233 Wood Side Drive, Great Diamond Island, Permit #00757

Christina Stacey <cstacey@portlandmaine.gov>

Thu, Jun 29, 2017 at 2:02 PM

PROPOSED RESIDENCE 233 WOODSIDE DRIVE, GREAT DIAMOND ISLAND

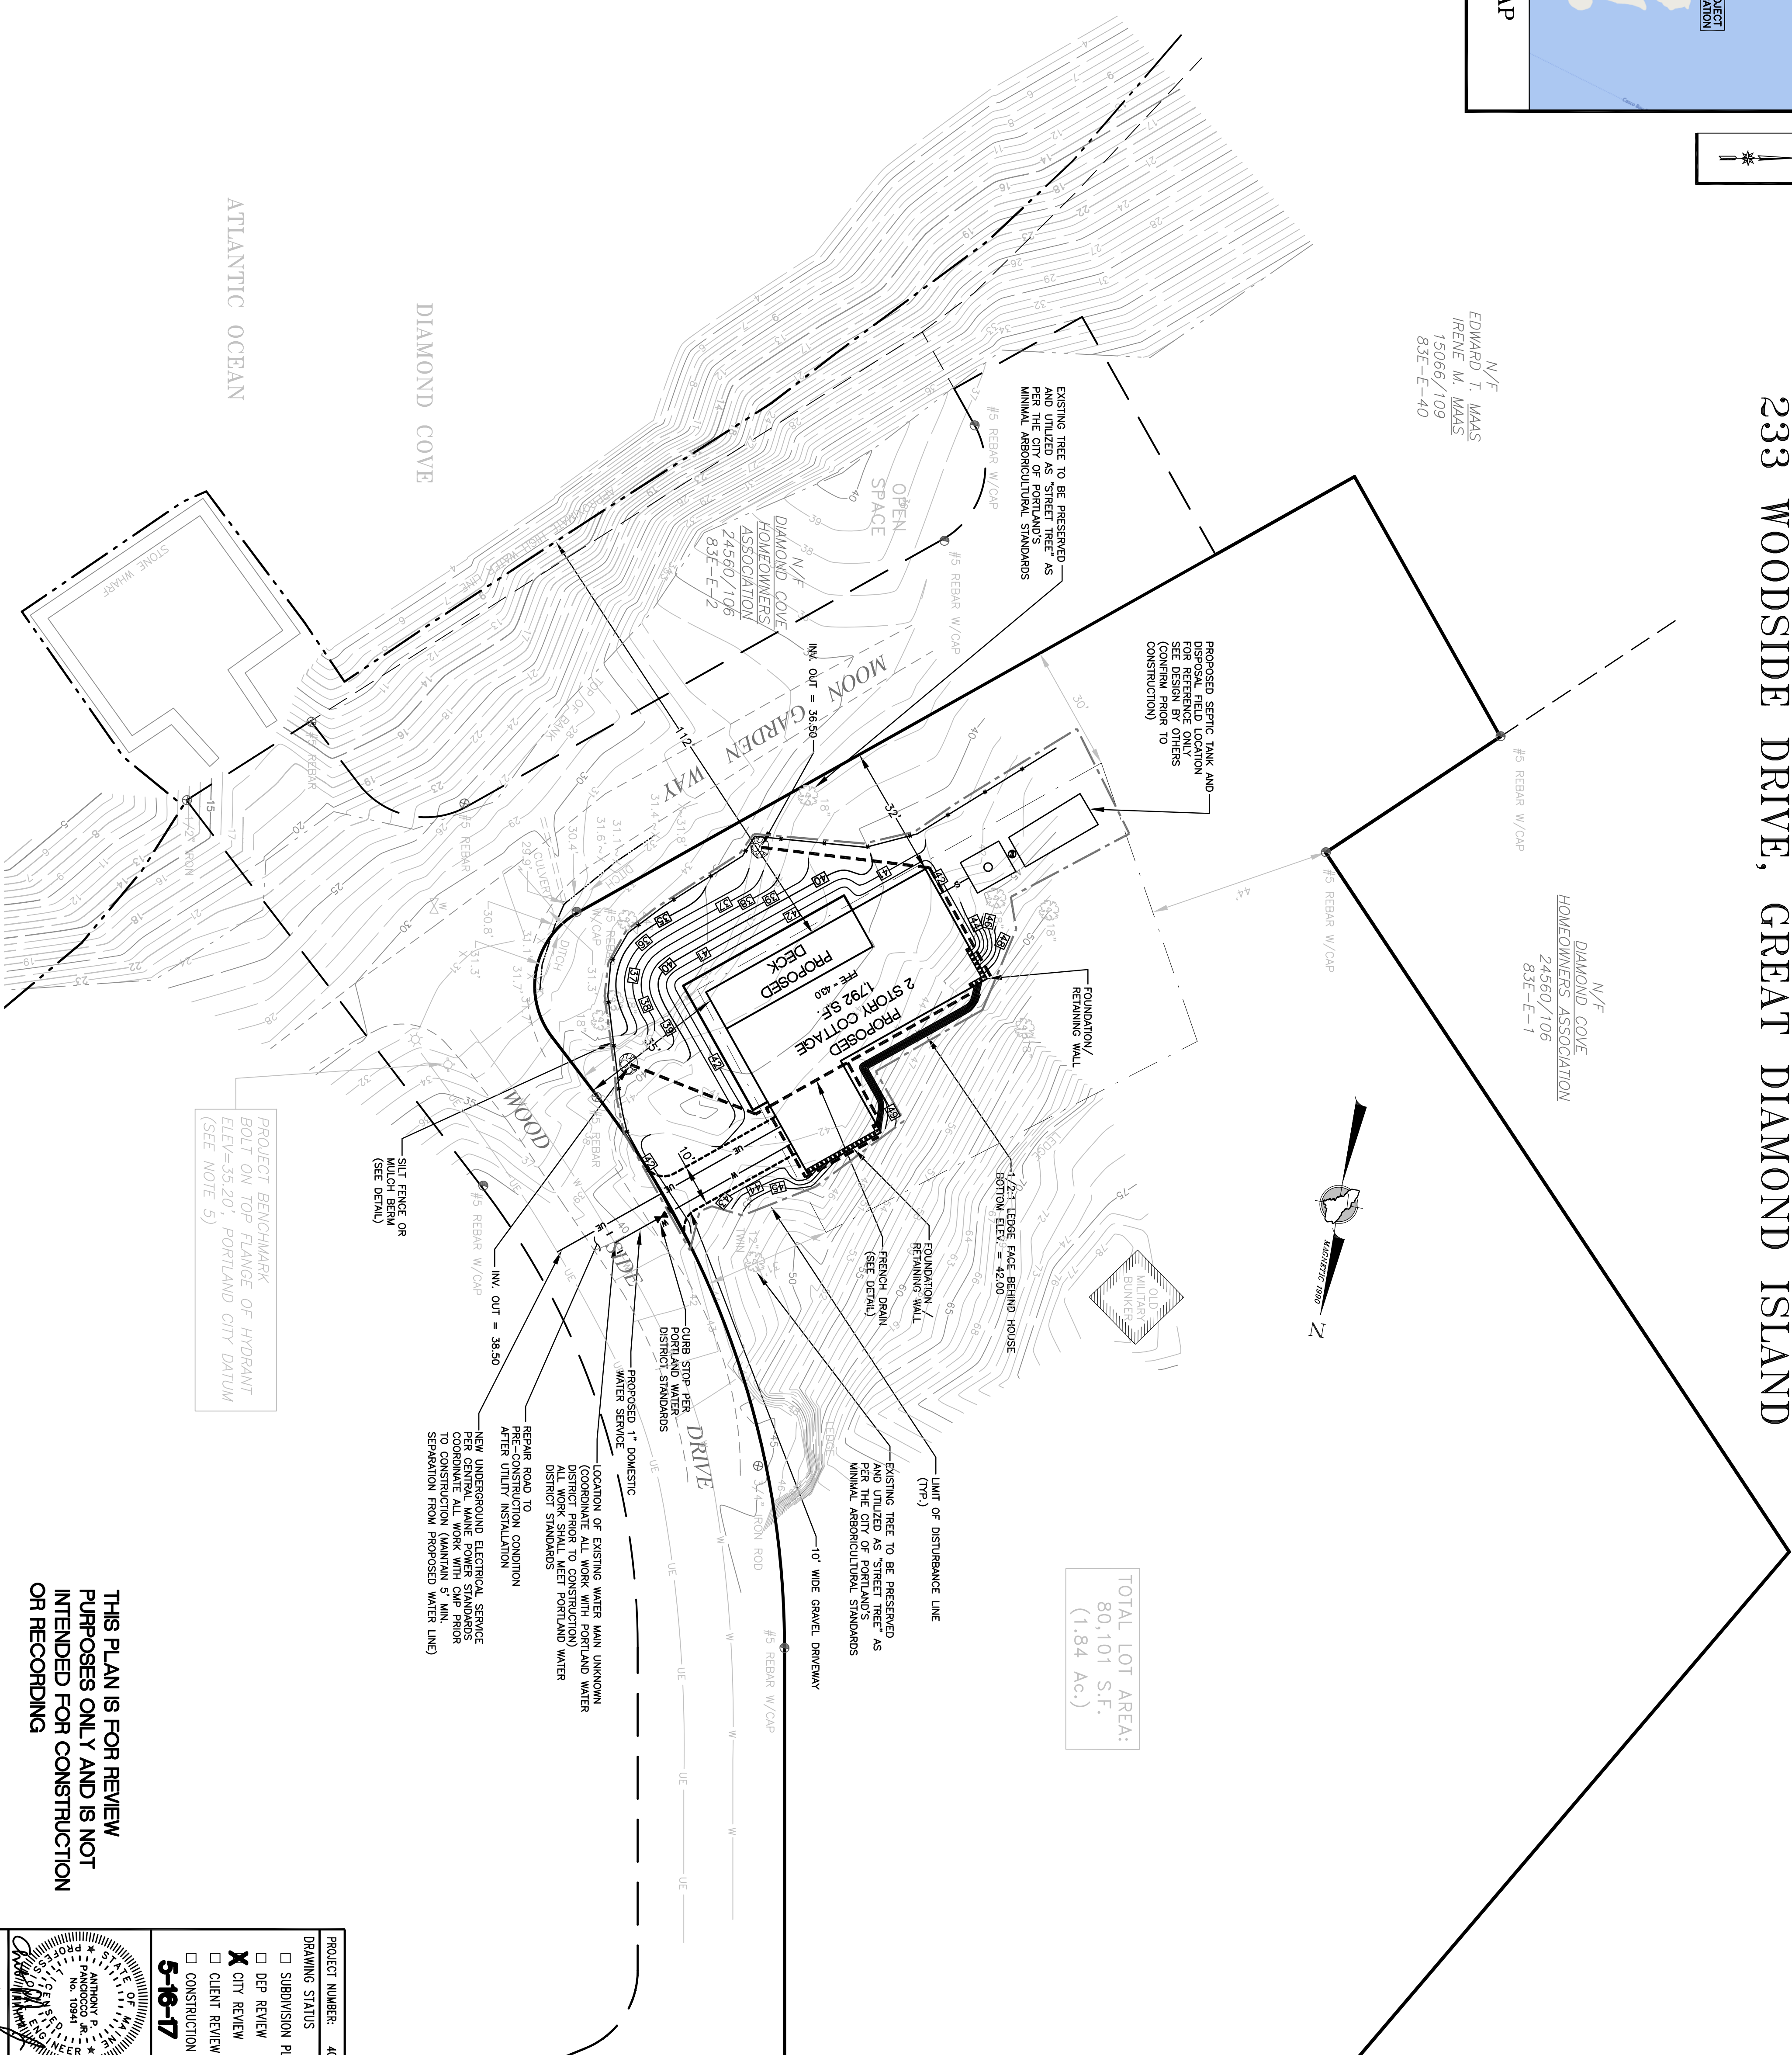
3. The floor plans also appear to be preliminary - no window locations are shown in bedrooms.
4. Site plan questions: a) What is the "wrap around" structure shown in front of the deck and around the north side of the house? b) The site plan does not depict the deck around the guest house and stairs down to the ground that are shown on the floor plans. c) The site plan needs to show Highest Annual Tide (HAT) line and the 75' HAT setback line.

5. There are some pages of the HHE-200 missing.
6. Shoreland zone clearing - confirm that the project will be meeting all standards of 14-449(c). Any cutting within the 75' HAT setback planned? Between 75' and 250' from HAT, cannot cut more than 40% volume of trees and cannot create an opening exceeding 25% of all lot area within the shoreland zone.

7. Site plan (this is really more Phil's concern, but I'll mention it) - It does not appear that an amended plat was required showing the new building envelope, as required under Site Plan review #2016-089. The approval also required that the site plan "document all trees and tree stumps 6" or greater in diameter on the water side of the lot." (I am not sure what the "water side" of the lot is).

I will defer to Northeast Civil for items 6 and 7, and 4c.

ELEVATIONS

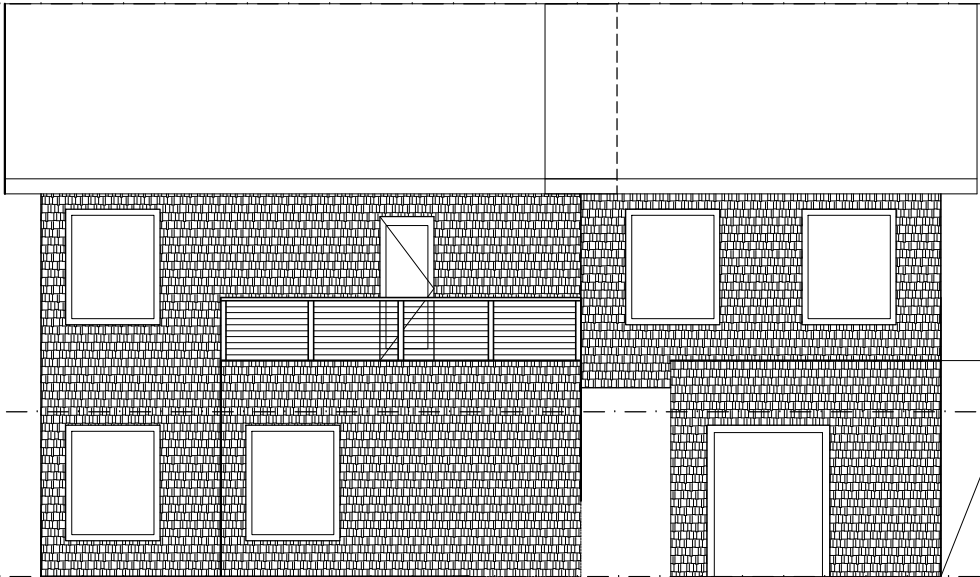
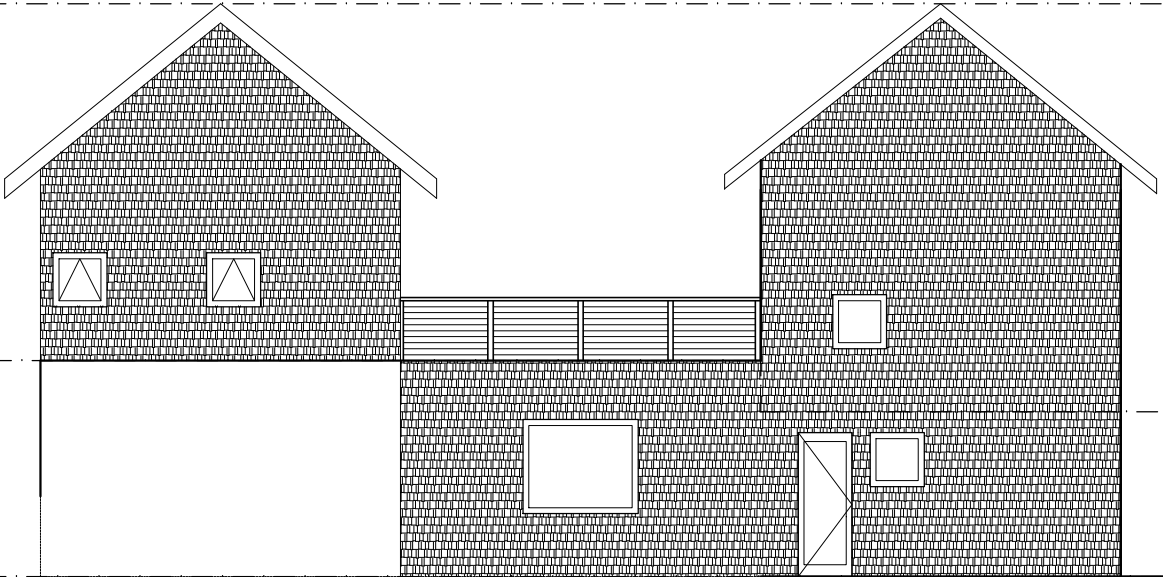
2. The building elevation views look unfinished or missing info - particularly side view #2 and rear view #3. There are large white/blank areas on the garage - is this correct?

A200 will help clarify your elevation questions. The golf cart garage is being built to conform to the ledge of the rising hill behind the house. The foundation details for this in accordance with the foundation plan. Essentially the back of the garage grade is close to the second floor elevation (so the white area on the rear elevation there is ground). And therefore the two sidewalls then return to the lower grade at first floor. The exact shape of those will be determined by the ledge removal to get to solid ledge. I hope this makes sense.
